CITY OF ALBUQUERQUE

March 9, 2012

**Re: Storm Cloud Subdivision, Units 4 & 5
Drainage Report
Engineer's Stamp Date 2/10/2012 (H9/D022)**

STORM CLOUD SUBDIVISION, UNIT 5 RETAINING WALL PLAN WALH, LLC.			
RETAINING WALL PLAN			
Date:	NOV. 2011	Date:	Job No. 1822
Drawn By:	ANW		PAGE
Ckd By:			SH 5 OF 7

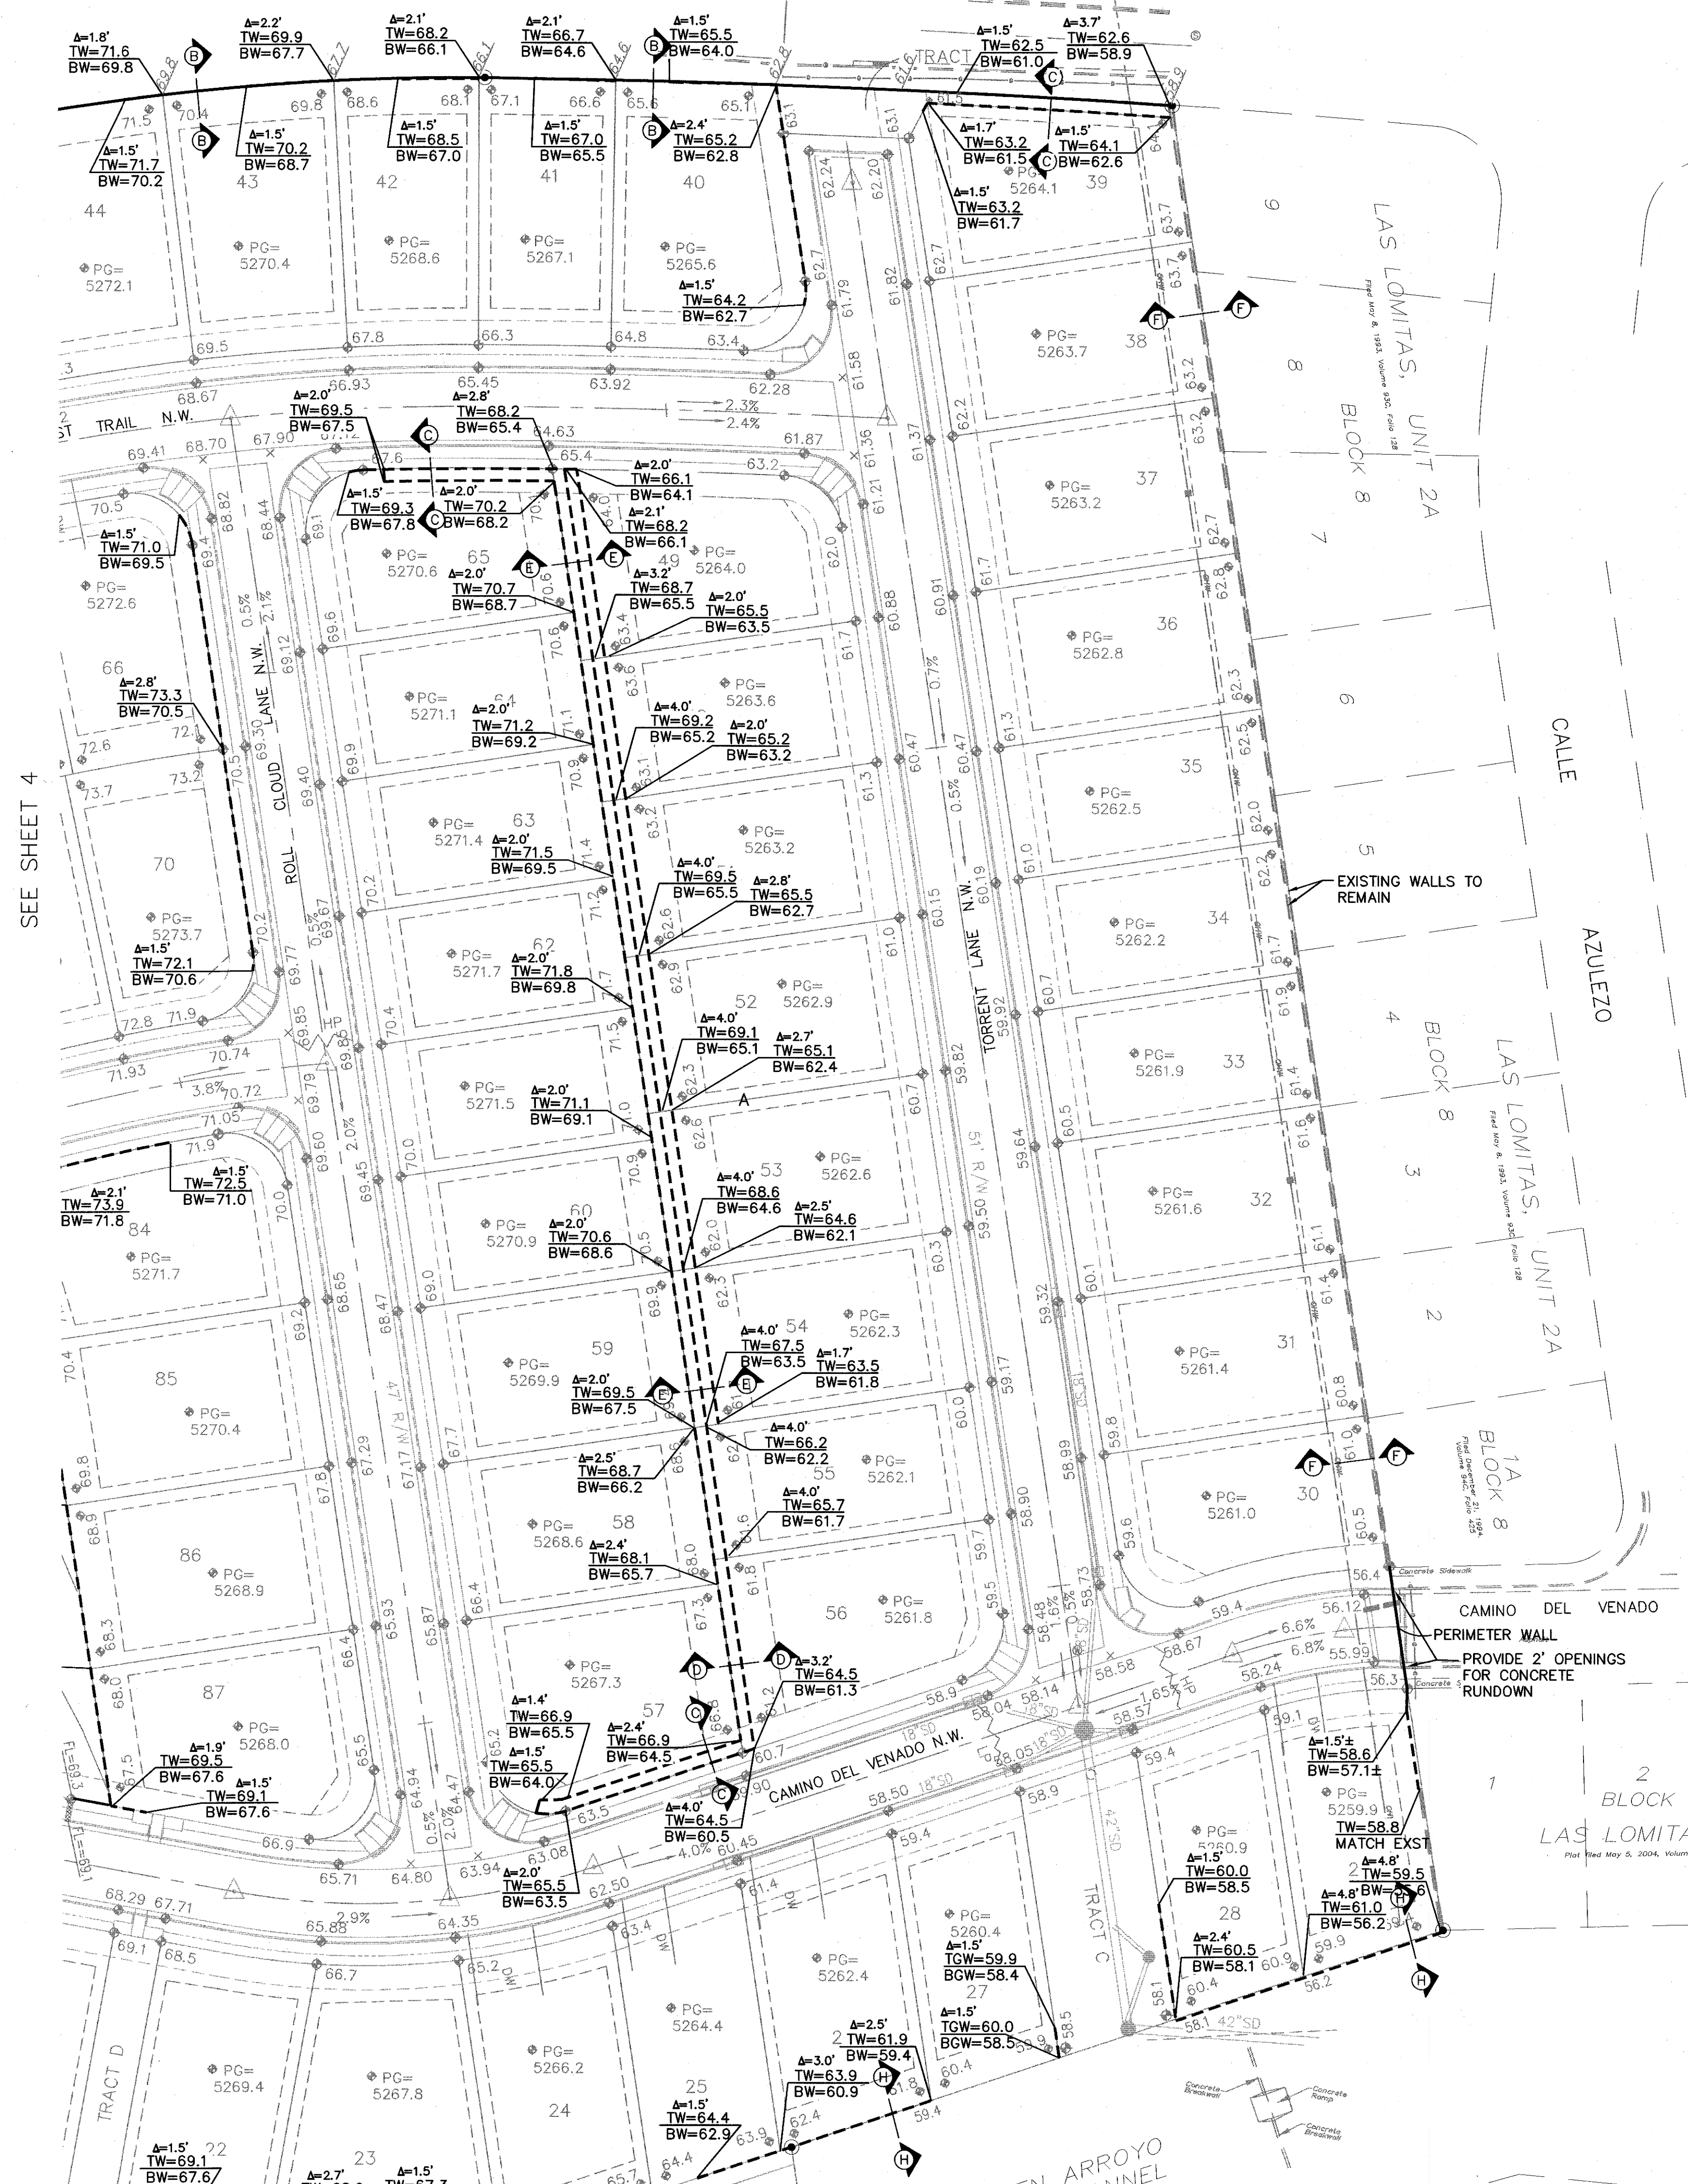
- Fix the text overlaps on the grading plans.
- Clearly show all the existing retaining walls, and label the retaining walls that will be removed.

- If the retaining wall will not be certified with the certification of the grading plan, the following not should be added to the plans: "The side and rear lot retaining walls will be constructed by home builders.
- Proposed legends for curb and gutters does not match what the actual layout on the grading plans.
